**Subject:** BL-26-00002 Fowler Creek Trails - Notice of Application

Please review the following Boundary Line Adjustment Application: BL-26-00002 Fowler Creek Trails. Any comments need to be received by **5 PM on March 31, 2026**.

**TO:** All Staff  
**FROM:** Public Works Plan Review Team  
**DATE:** March 30, 2026  
**SUBJECT:** BL-26-00002 Fowler Creek Trails

RECORD OF SURVEY A PORTION OF THE NE 1/4 OF SECTION 3, TOWNSHIP 19 NORTH, RANGE 14 EAST, W.M., KITITAS COUNTY, WASHINGTON

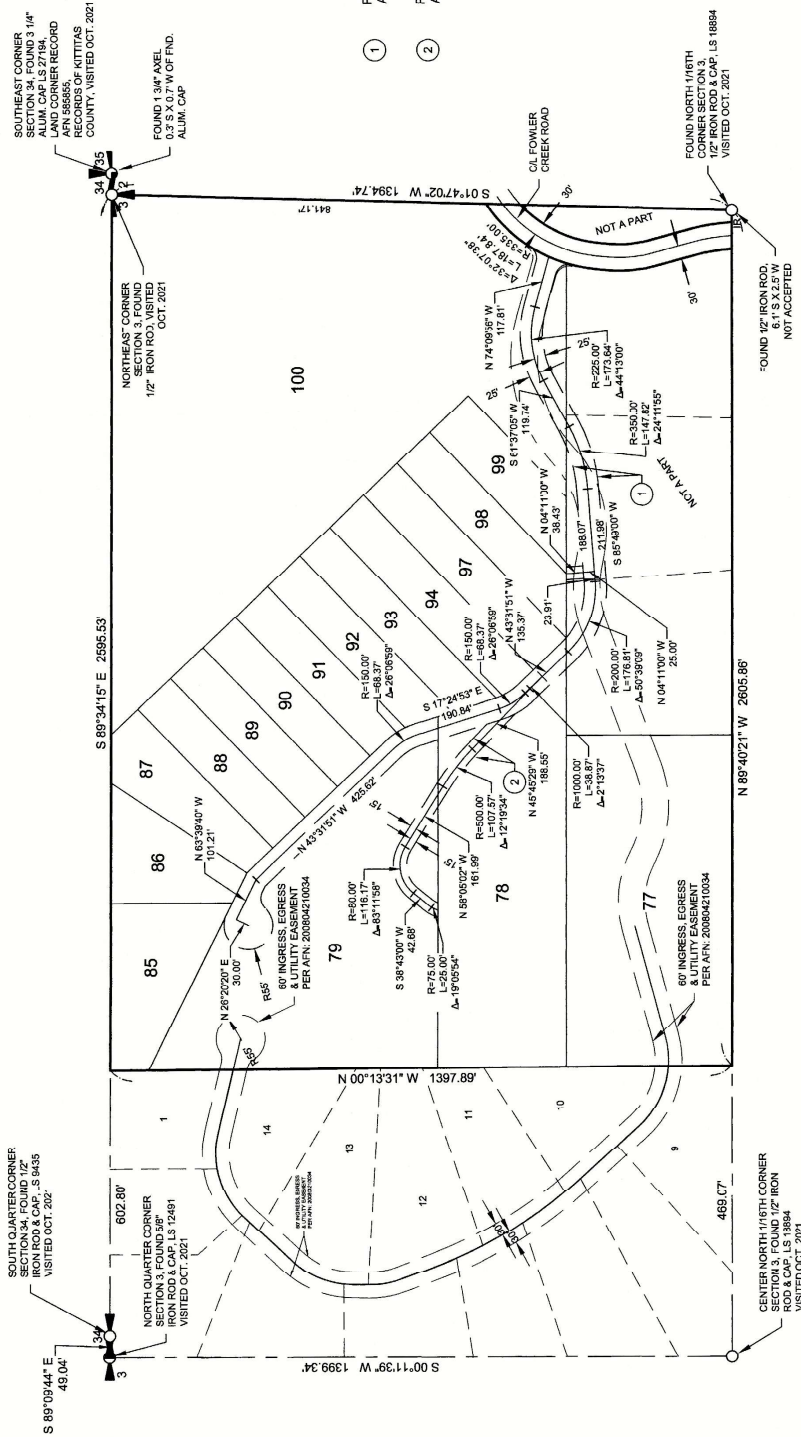
<b>Drinking Water</b>	<ul style="list-style-type: none"><li>I spoke with Pat Deneen about the 2 wells on the Fowler Creek Trail map to get clarification. The well in between lots 87 and 88 serves the Granite Creek Water system and the well on lot 85 and 90 serves the house on lot 77. Therefore, this well must meet the set back of 50' from property lines as per 13.20.040 county code.</li></ul>
<b>Wastewater</b>	<ul style="list-style-type: none"><li>No permits were located for the septic system serving the house or associated parcels. All septic systems must meet required setbacks.</li></ul>

<b>ACCESS</b>	<ol style="list-style-type: none"> <li>1. Provide access easement to all lots, appears as the properties to the west on proposed site plan will no longer have an easement for access.</li> <li>2. An approved access permit shall be required from the Kittitas County Department of Public Works prior to creating any new driveway access or altering an existing access.</li> <li>3. Per KCC 12.04.04.050 Road Certification is required for road serving 4 or more parcels prior to final approval.</li> <li>4. Per KCC 12.04.01.030 Roads serving five or more lots shall be named according to the Kittitas County Private Road Naming &amp; Signing Standards prior to final approval.</li> <li>5. Maintenance of driveway approaches shall be the responsibility of the owner whose property they serve. The County will not maintain accesses.</li> <li>6. Any further subdivision or lots to be served by proposed access may result in further access requirements. See Kittitas County Road Standards.</li> </ol> <p>In addition to the above-mentioned conditions, all applicable Kittitas County Road Standards apply to this proposal. Access is not guaranteed to any existing or created parcel on this application. (RC)</p>
